From: Katherine Jenkins [REDACTED]
Sent: 20 February 2019 14:50
To: Laura Gibbons
Cc: Andrew Wood
Subject: Re: Planning Application FG/220/18/PL : Land adjacent to Elm Lodge, Tamarisk Way, Ferring, West Sussex BN12 5ER

Subject: RE: Planning Application FG/220/18/PL : Land adjacent to Elm Lodge, Tamarisk Way, Ferring, West Sussex BN12 5ER

Laura Gibbons, MEng, GMICE
Engineer (Drainage & Coastal)

Drawing Title **PROPOSED POND ACCESS
PLAN**

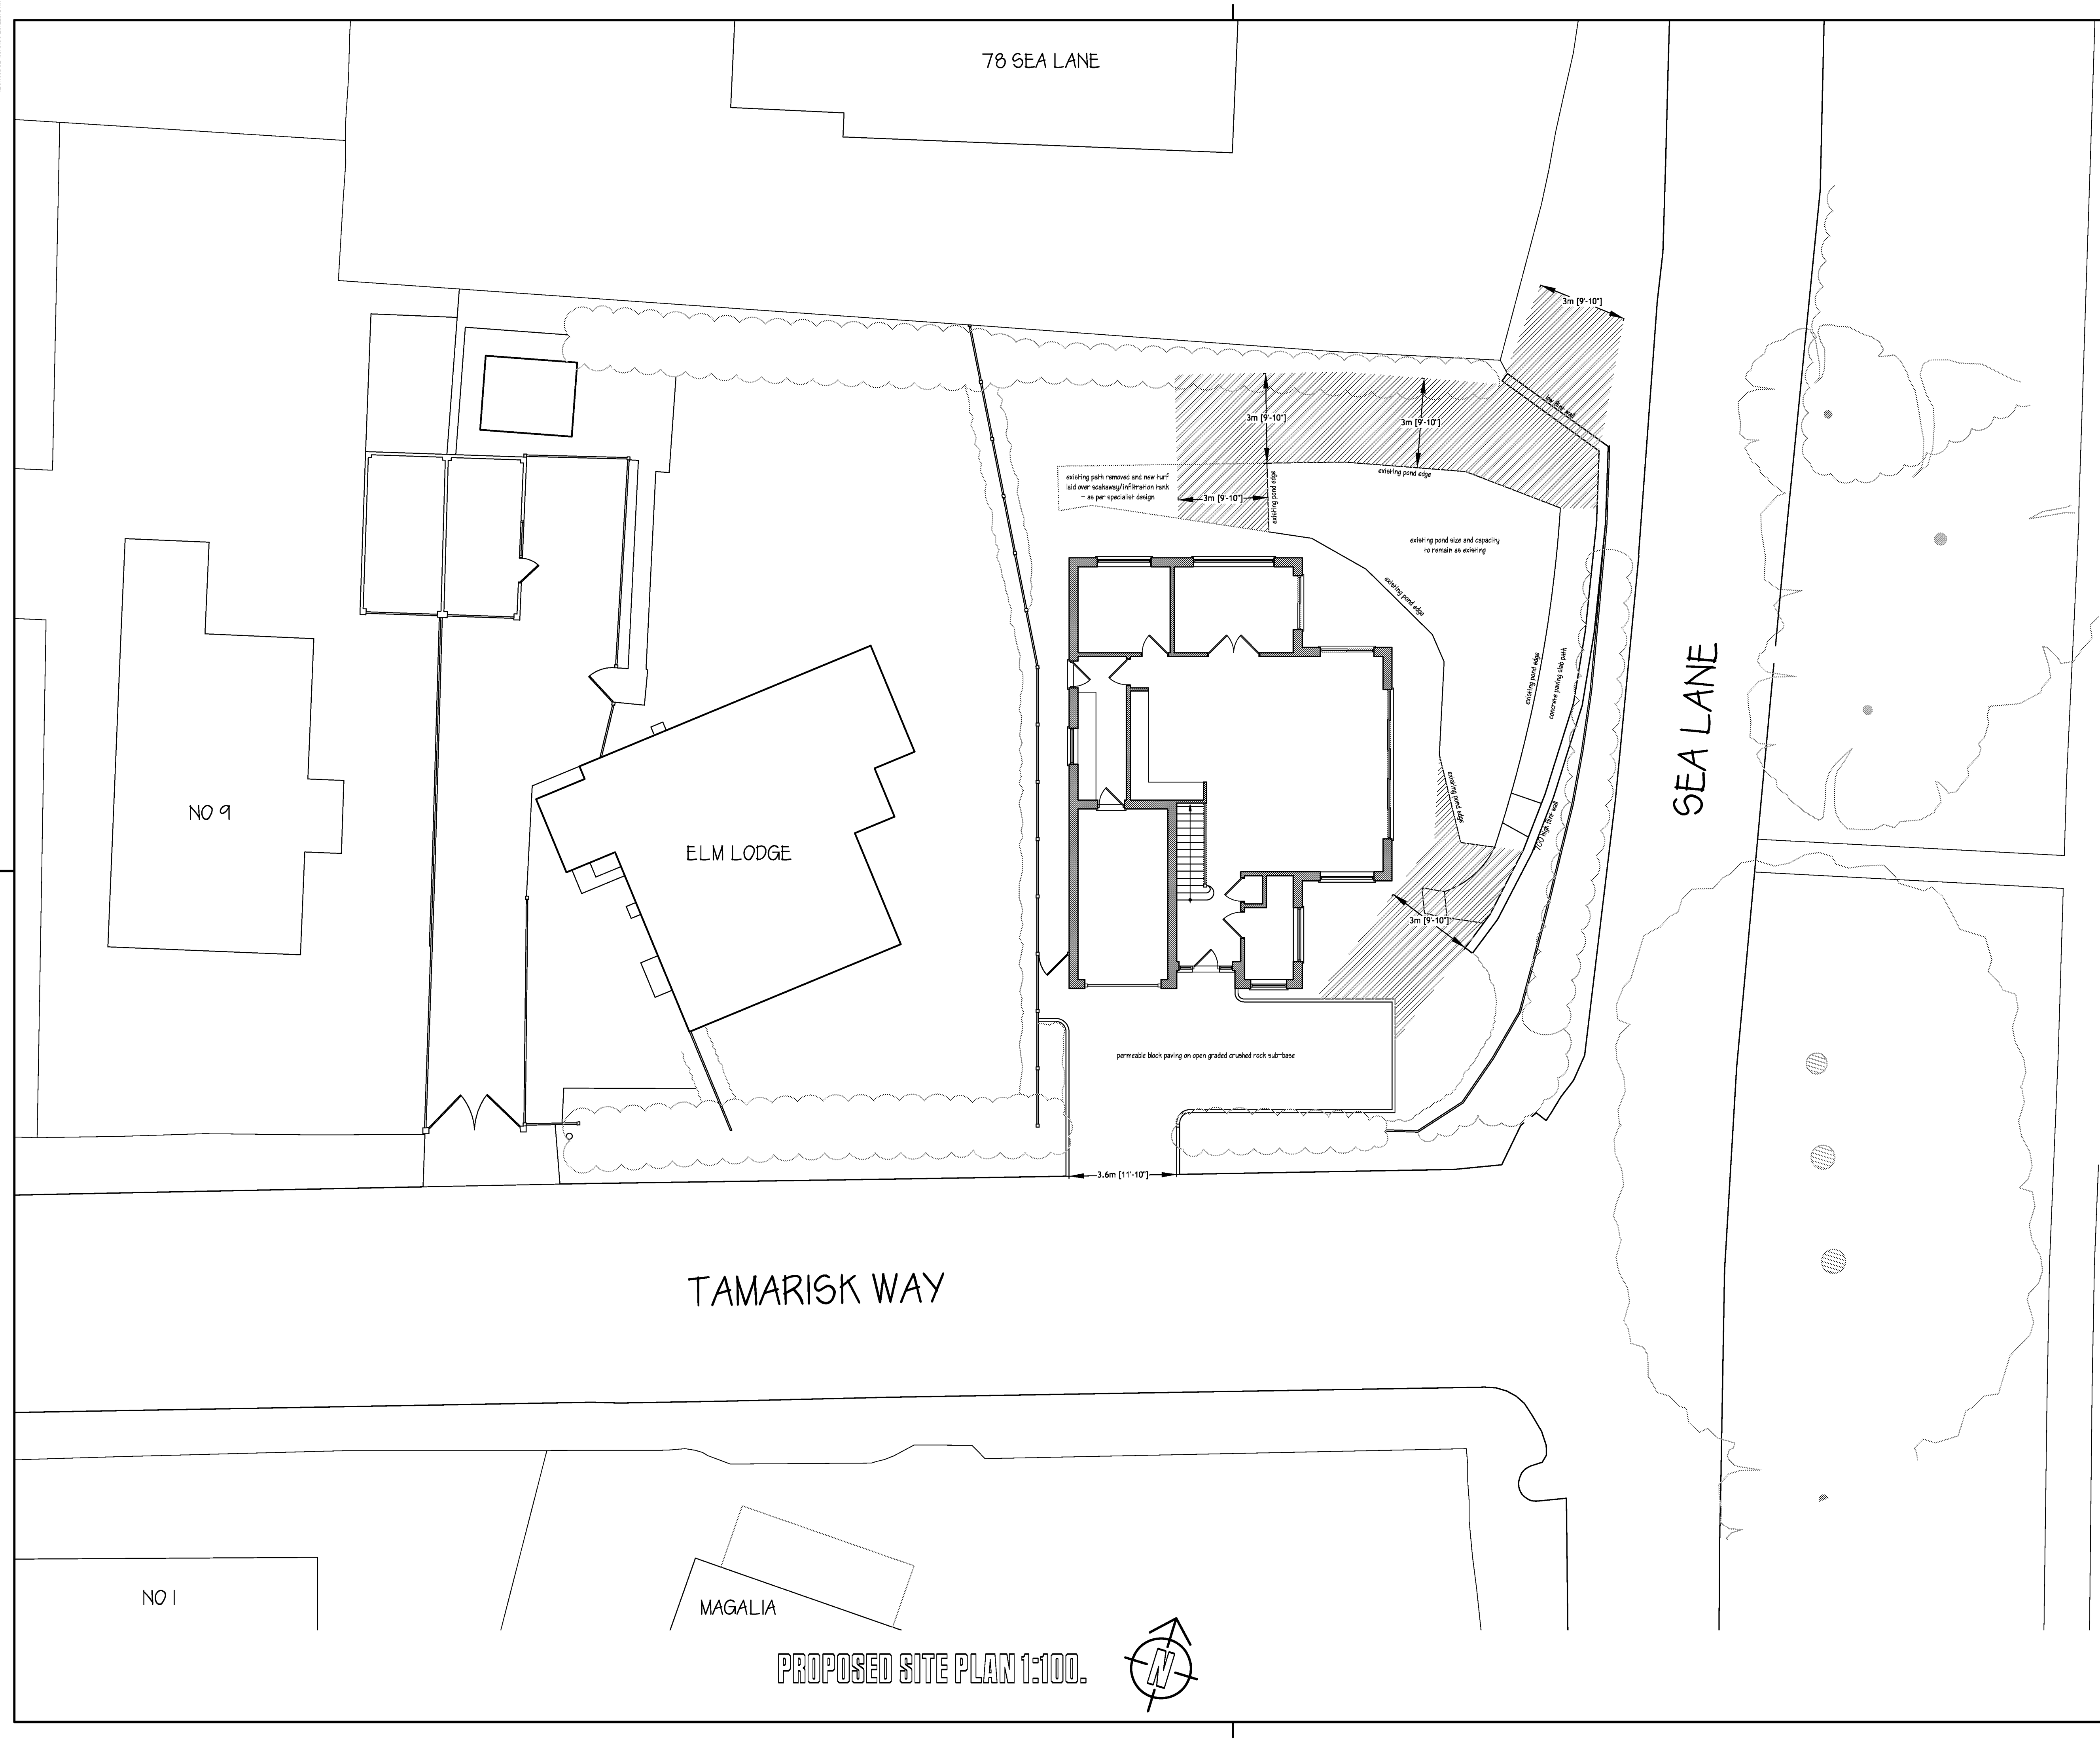
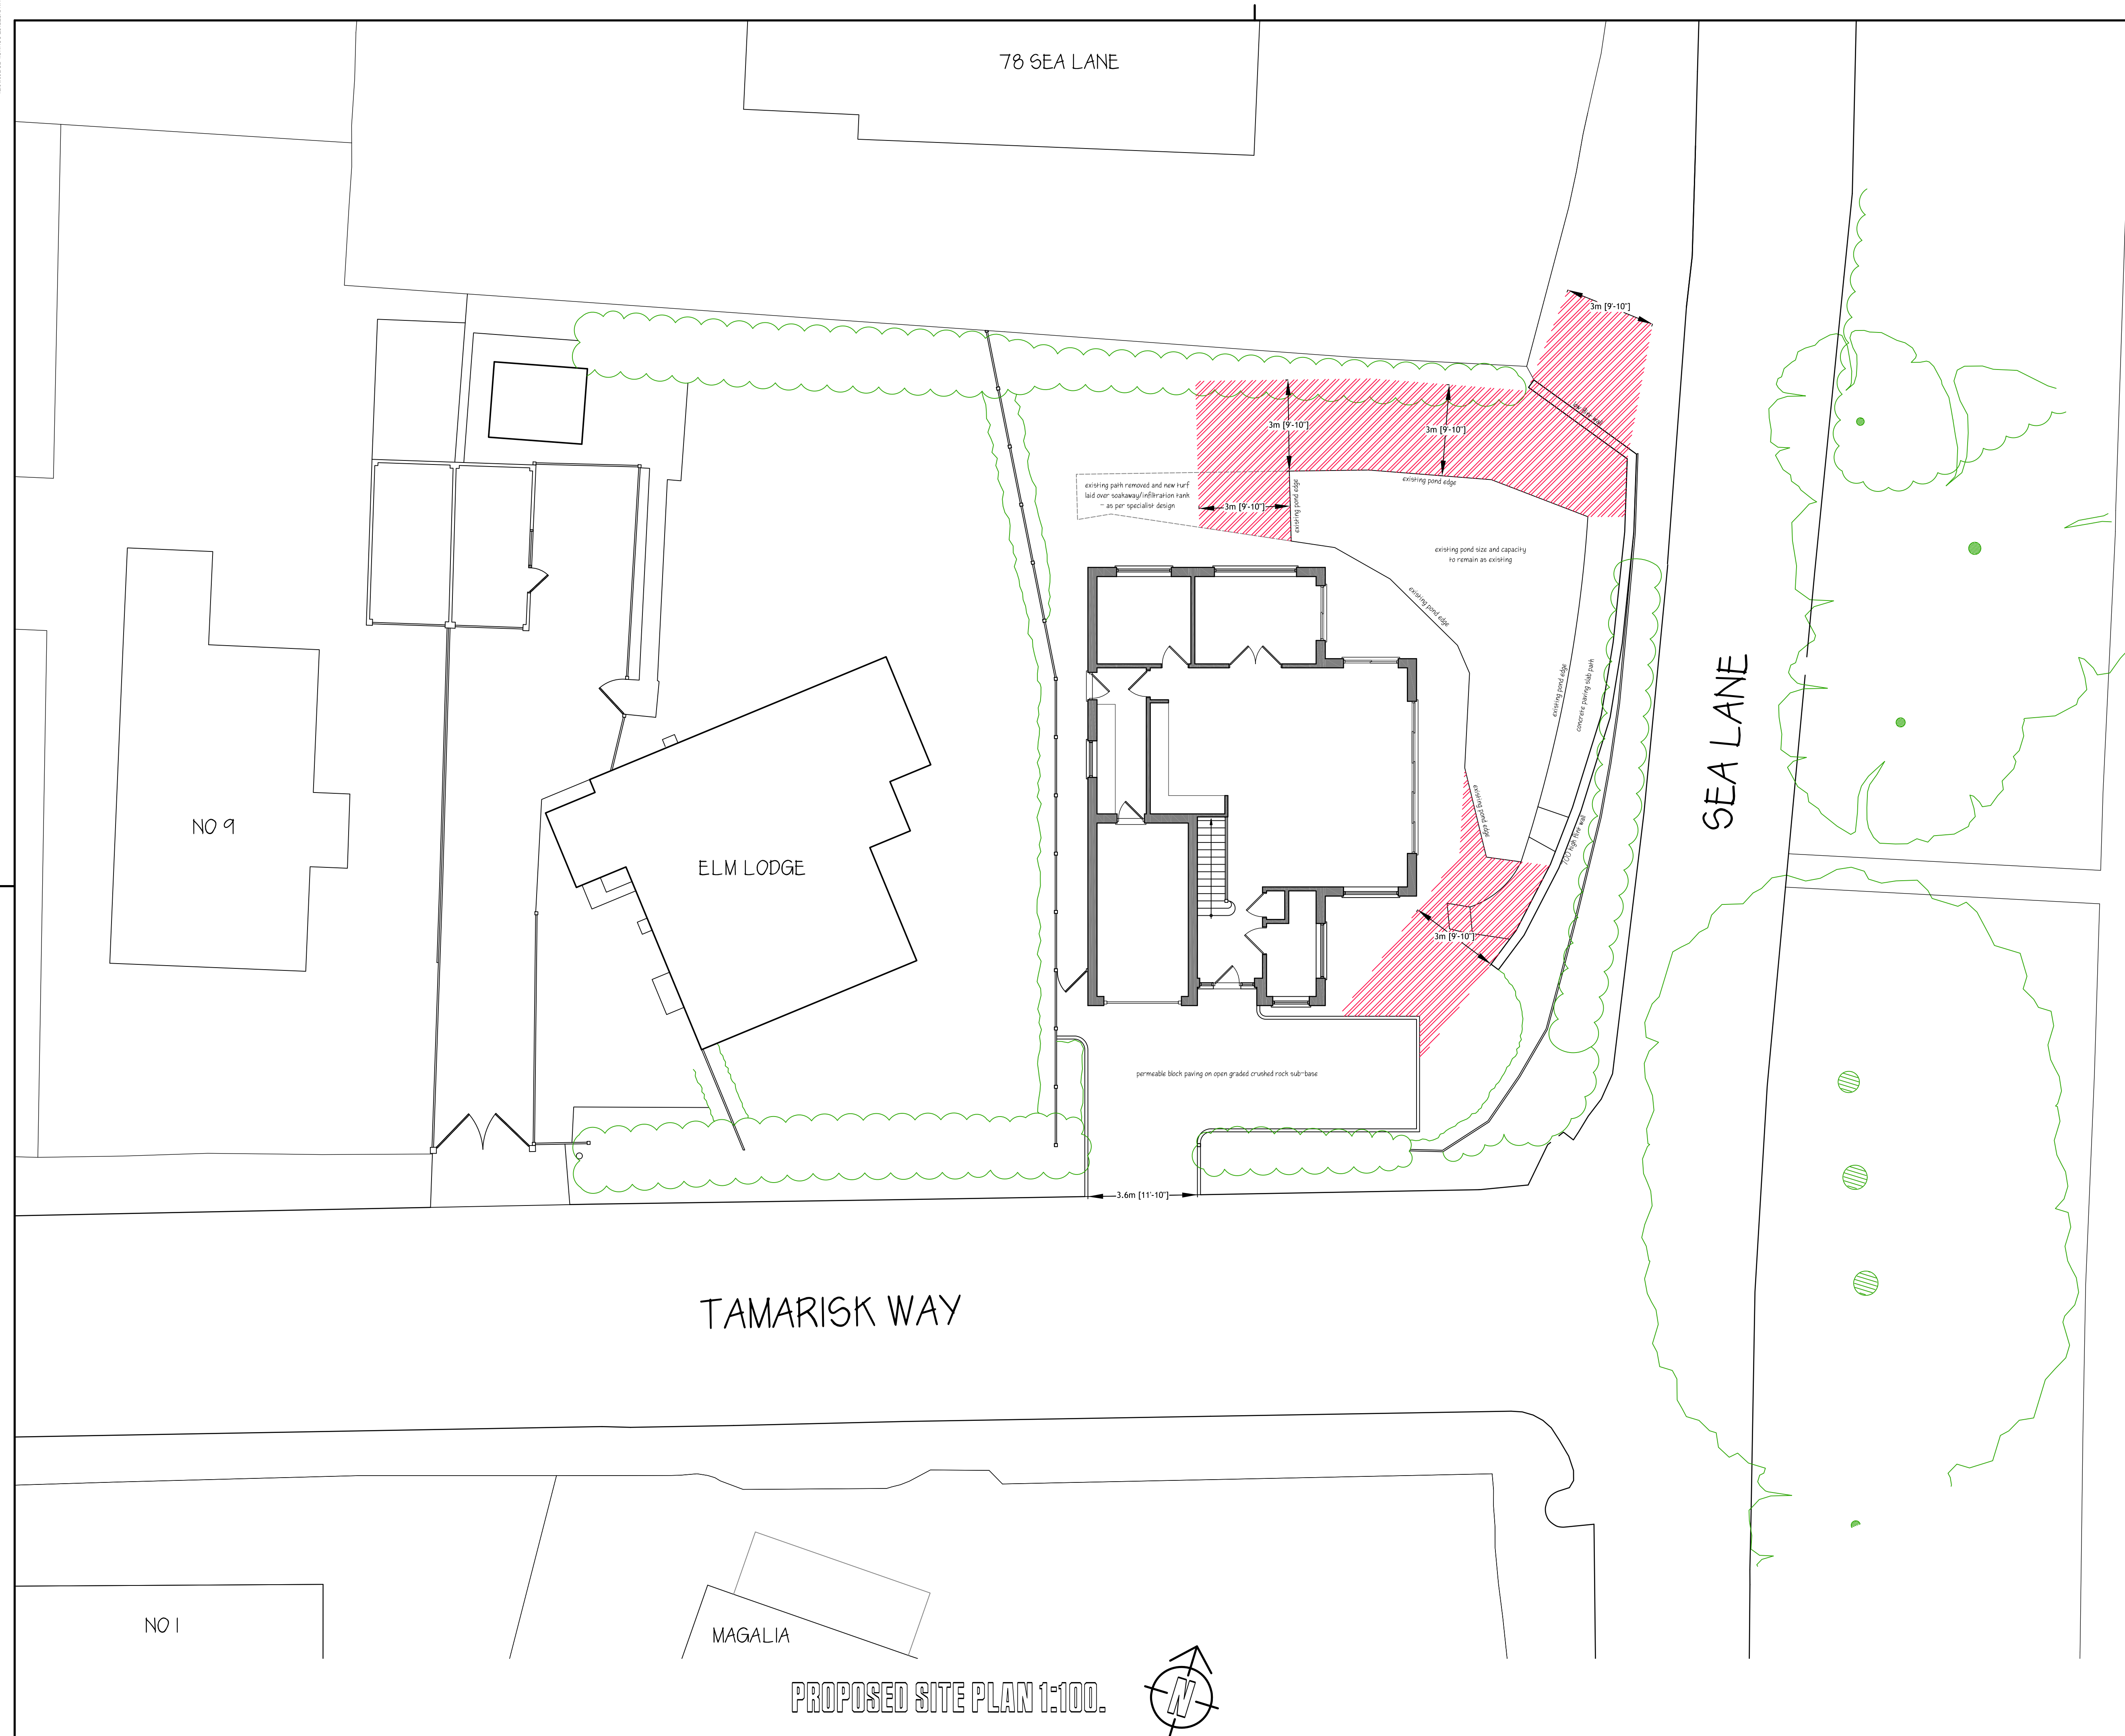
2. I am not keen to see the building go up to within 0.8m of the pond. Access and erosion are both a concern. I would therefore be keen to see the building layout revised to provide more easement. As shown on the proposed indicative part foundation section detail, short bore piles would be positioned a minimum of 3m from any edge of the pond, reducing the risk of erosion by eliminating trench foundations. Given a specialist would be designing the reinforcement/camp shedding for the existing edge of the pond (again, to be agreed with ADC by condition prior to commencement), this would ensure there will be no erosion. Given the building would only be cantilevered at one point within 0.8m of the pond, there is still a large area of access around the east and all other parts of the pond. We note that ADC has never had to access the pond to carry out any maintenance works to date, therefore query why there is such an onerous requirement for access now. We also note that ADC cannot currently access the pond with plant, since we have gates to the

3. It is my belief that there is no way to get to the northern and western portions of the pond without tracking through the pond itself. This would mean that maintenance would have to be completed in the summer by the landowner when water levels are lower. This would then be within nesting bird season. I would much prefer an access to be provided around the pond. I note that you state the 1m wide path to the east could take plant but this plant would not be big enough. As explained above, we as landowners can continue to access the pond from all sides, with 3m to the West, North and South East. We cannot understand what plant would ever be required (given no plant has ever needed to access the pond before, and any plant necessary for carrying out works to the pond can have full access from all sides as part of the building works) that would ever be larger than a small digger, which can easily be maneuvered up the 1m side access to the west of site and around the rear.

Further to our meeting at the land adjacent to Elm Lodge, Tamarisk Way, Ferring, West Sussex BN12 5ER on 12th February 2018, please find attached the existing and proposed pond access plans as requested. These show the existing pond to be retained in its entirety, with 3m access provided should Arun District Council ever need to access our property to maintain the pond. We hope these now alleviate your concerns regarding potential future access. We also note that the path to the east of the pond is also over 1m wide, which can currently comfortably accommodate a 1.5 ton digger to carry out any works. Given that there are multiple points of entry along the edge of the pond, any further work can be carried out from within the pond.
